City of Albuquerque Stormwater Construction Site Inspection Report

| General Information | | | | | |
|---|---|--|-------------------------|---------------|-----------|
| ESC File No. | L21E059B | Project Name: | Take 5 Car Wash Central | | |
| NPDES Id. No. | NMRI005E8 | Location: | 10415 Central Ave NE | | |

SWPPP

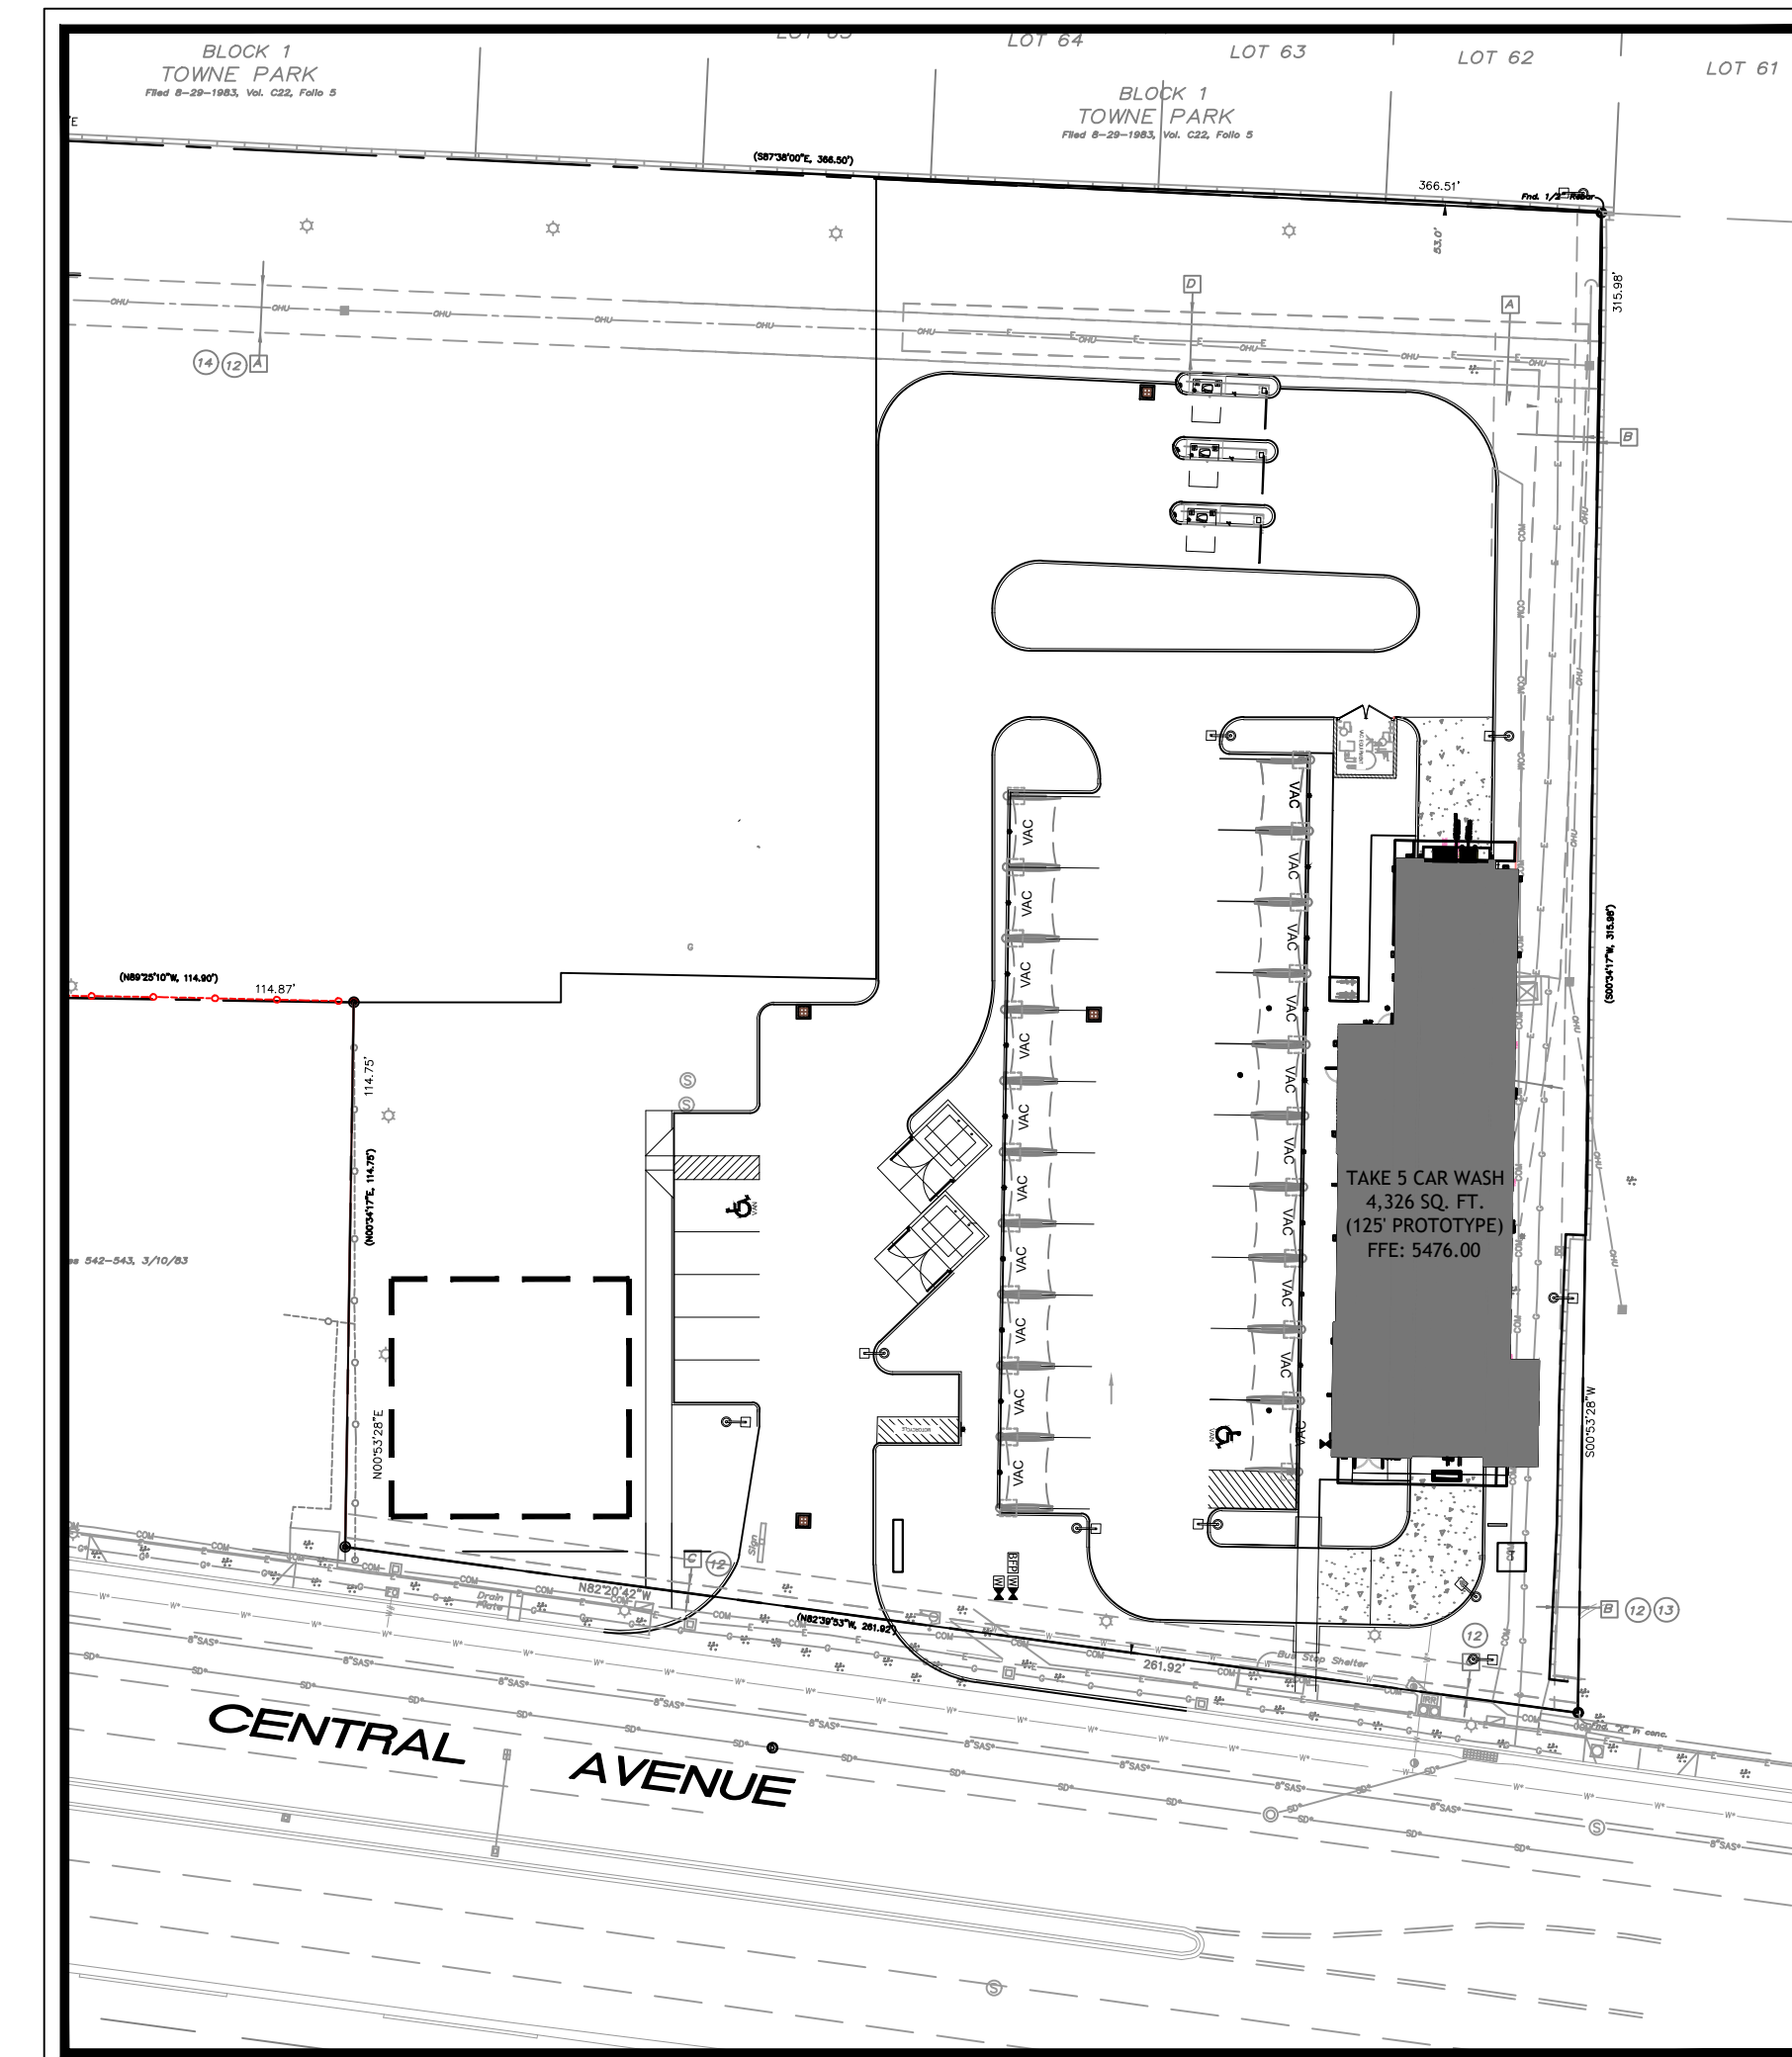
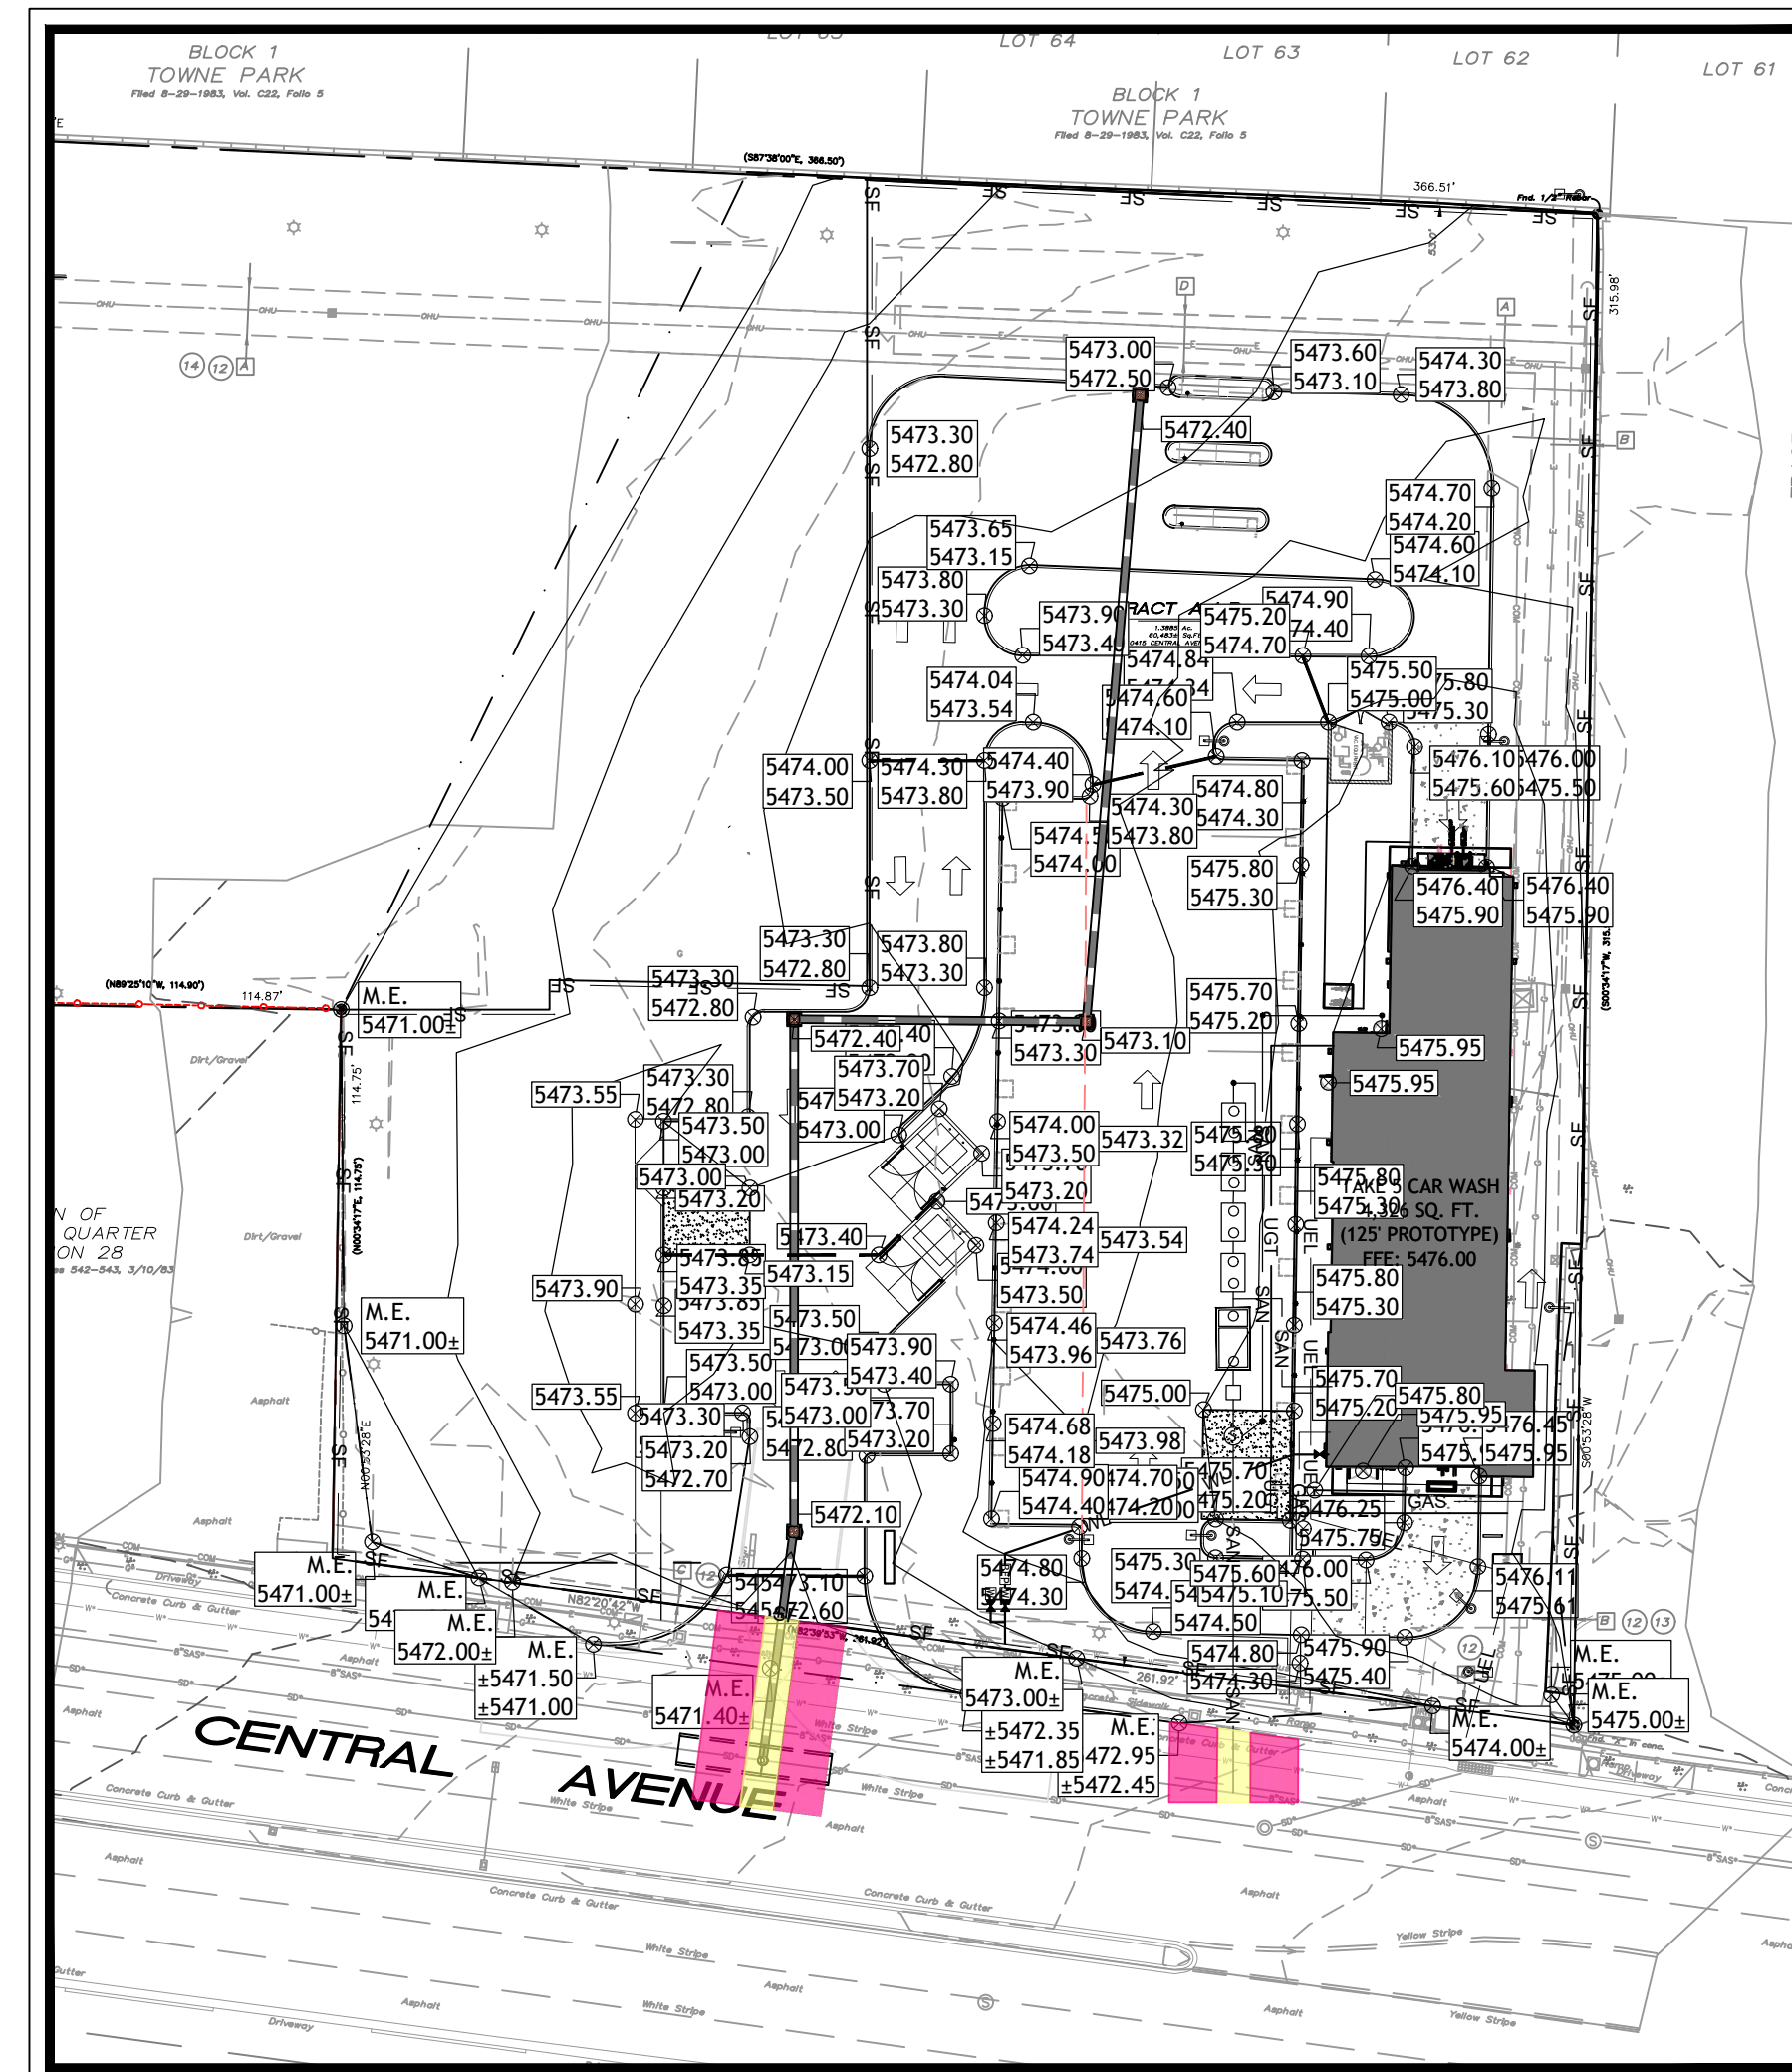
| 3 | BMP - The perimeter stormwater controls (silt fence and wattles) need repair and maintenance in violation of CGP Part 2.1.4. Required mitigation: Ensure that all stormwater controls (BMPs) are maintained and remain in effective operating condition during permit coverage per CGP 2.1.4. If at any time you find that a stormwater control needs routine Maintenance, you must immediately initiate the needed maintenance work and complete such work by the close of the next business day per CGP 2.1.4.b. When the problem requires a new or replacement control or significant repair, install the new or modified control and make it operational or complete the repair by no later than seven (7) calendar days from the time of discovery per CGP 5.2.1. | | | |
